BICESTERBUG

Submissions On Proposed Planning Application: 21/01454/F Graven Hill Surgery

**27 May 2021
Version 1.0**

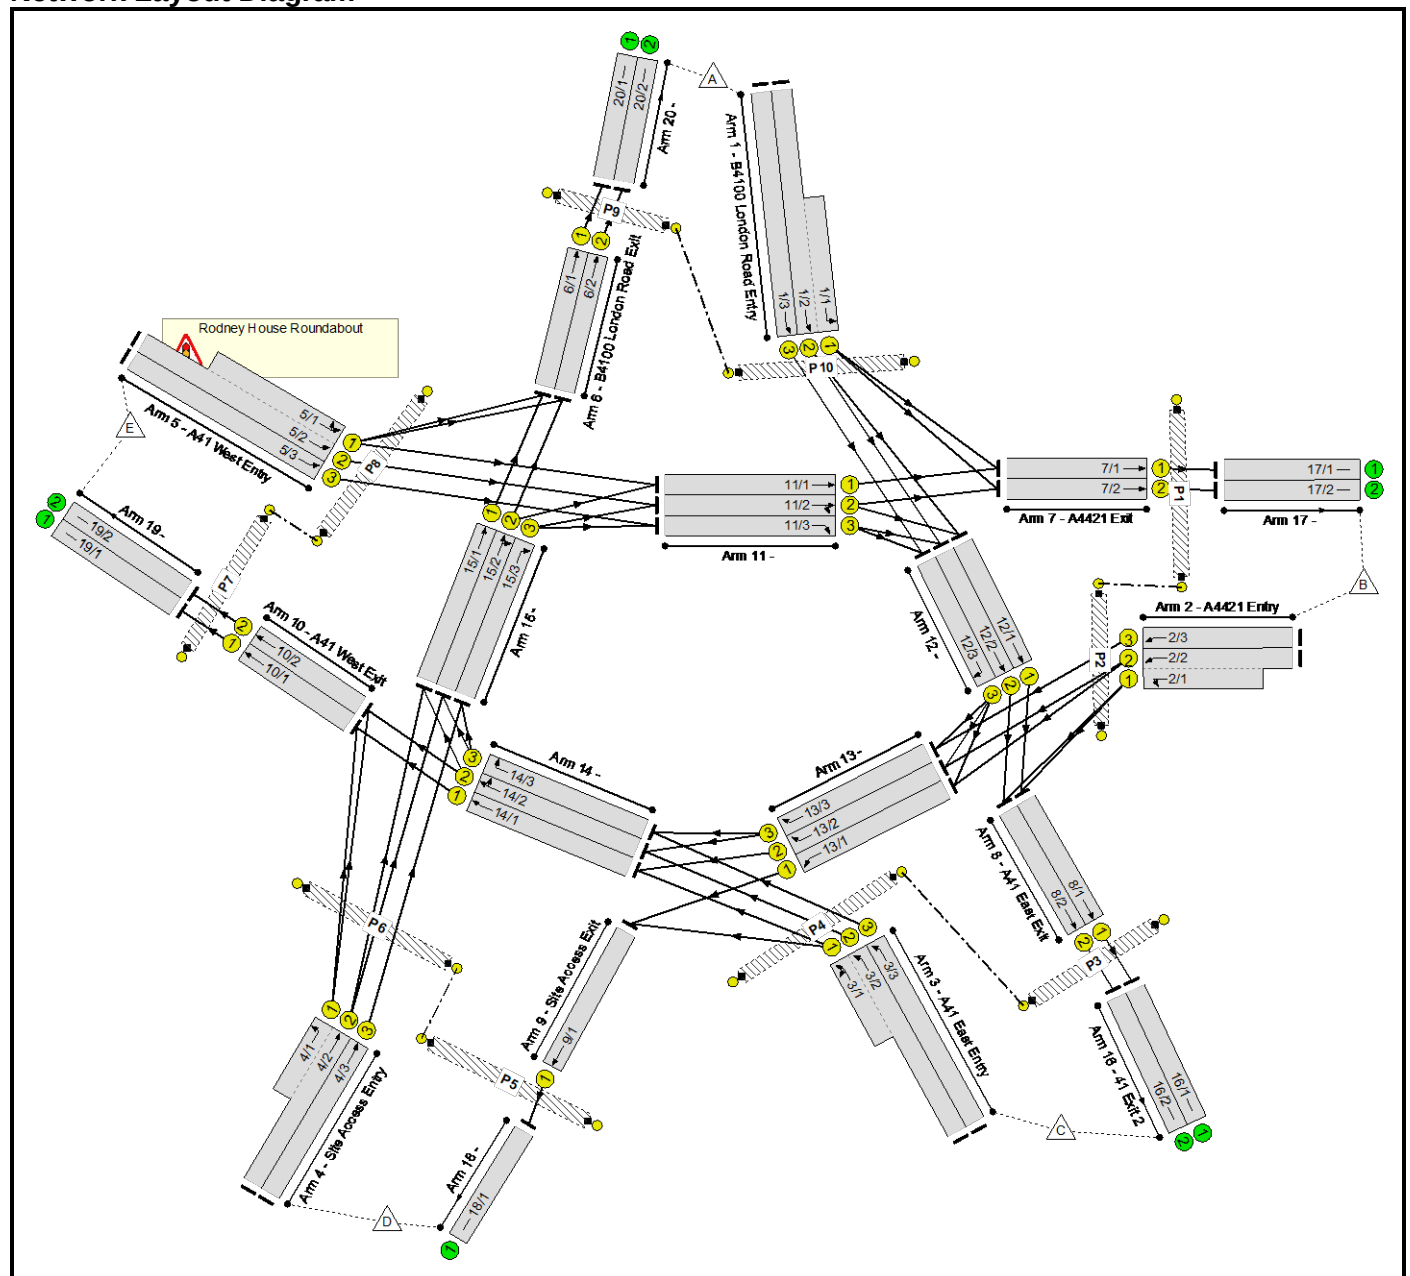
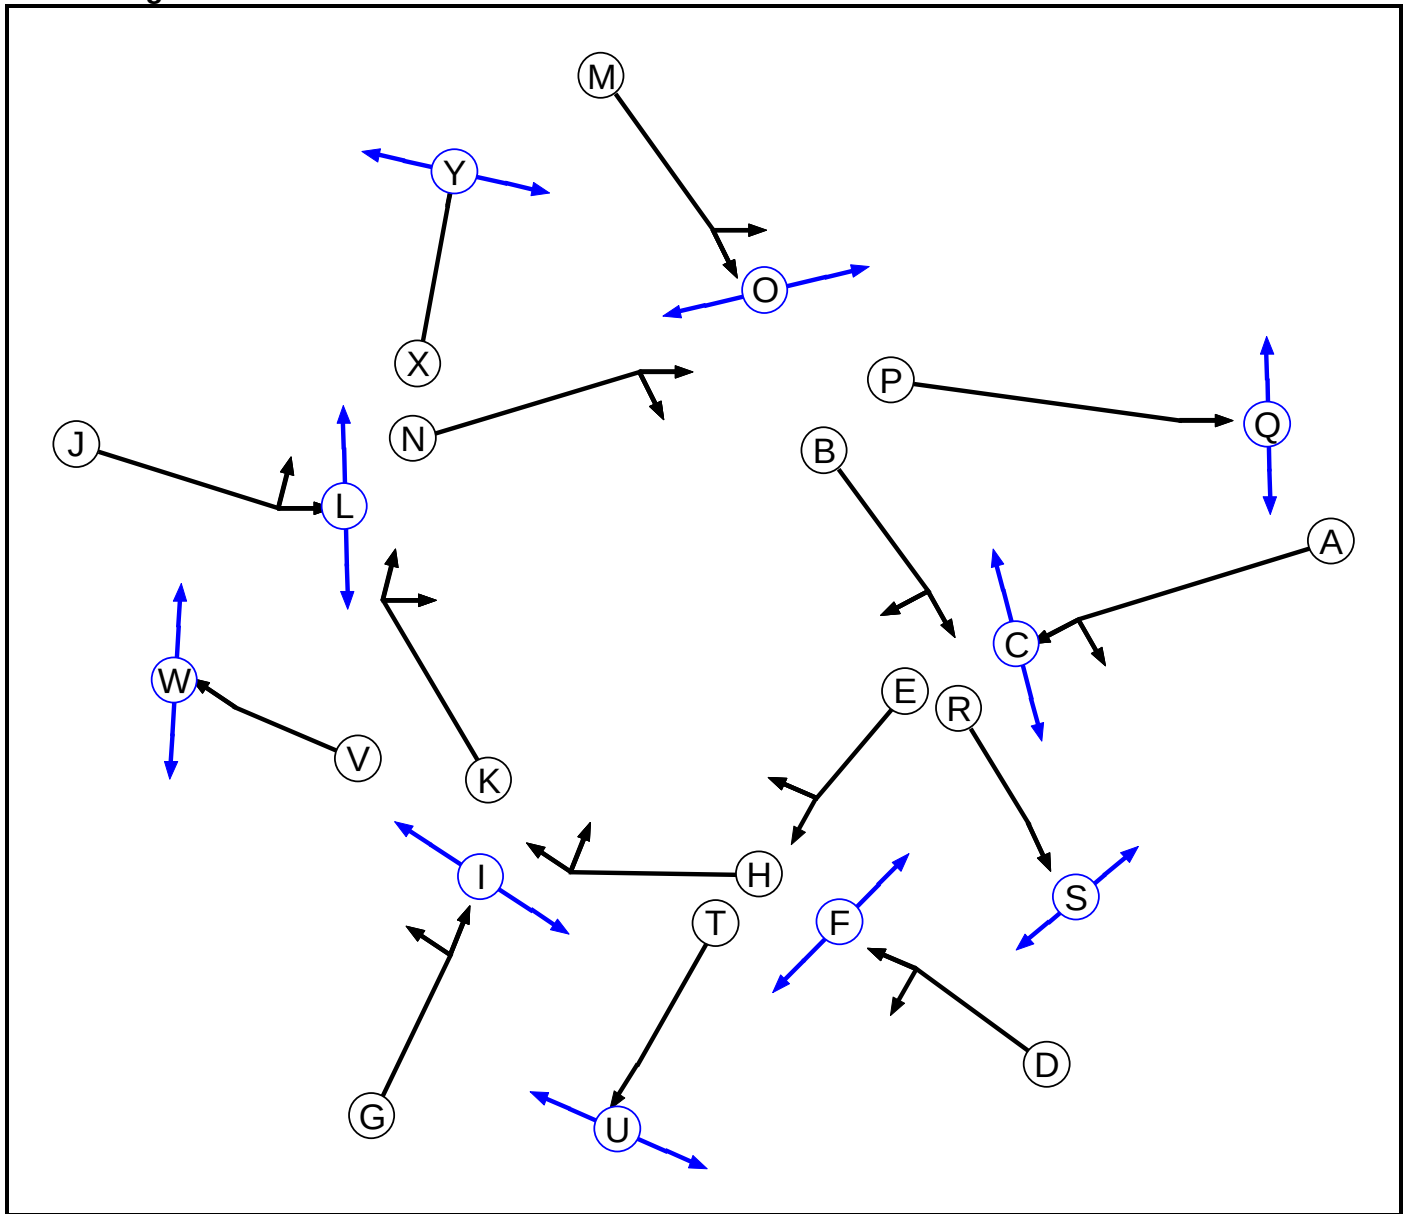
7. The junction to the entrance, the Rodney House junction, was designed and constructed by Graven Hill Village Development Company Ltd ('GHVDC'). It is dangerous and intimidating to all but the most courageous pedestrians and cyclists. Vehicles travel at very high speeds, there have been numerous accidents, the barriers (used for keeping pedestrians off the carriageway, not to protect pedestrians as the applicant erroneously states) have been destroyed by vehicles so repeatedly and in so many places that the developer has taken them out entirely in places, the crossings are poor and vehicles regularly drive over them when the pedestrian light is green, the light timings are ponderous meaning that it can take 5 minutes simply to cross the 75m from one side to another, and the desire lines are practically non-existent meaning that any pedestrian has to take a long, circuitous, and confusing route to attempt to navigate the junction. Currently it is the sole access route from many directions, but is so discouraging that most potential walkers and cyclists do not attempt to walk or cycle.

8. Changes would need to be made to support walking and cycling via the Rodney House Roundabout. Suggestions would include reducing the speed limit to 30mph (which would in fact be required by guidance given that London Road and the Graven Hill site entrance will both be 30mph roads); removing the pedestrian barriers (which, counter-intuitively, will reduce motor vehicle speeds); amending the timing of the crossings to expedite walking and cycling access; and widening the shared pedestrian and cycle paths to the current local and national standards.
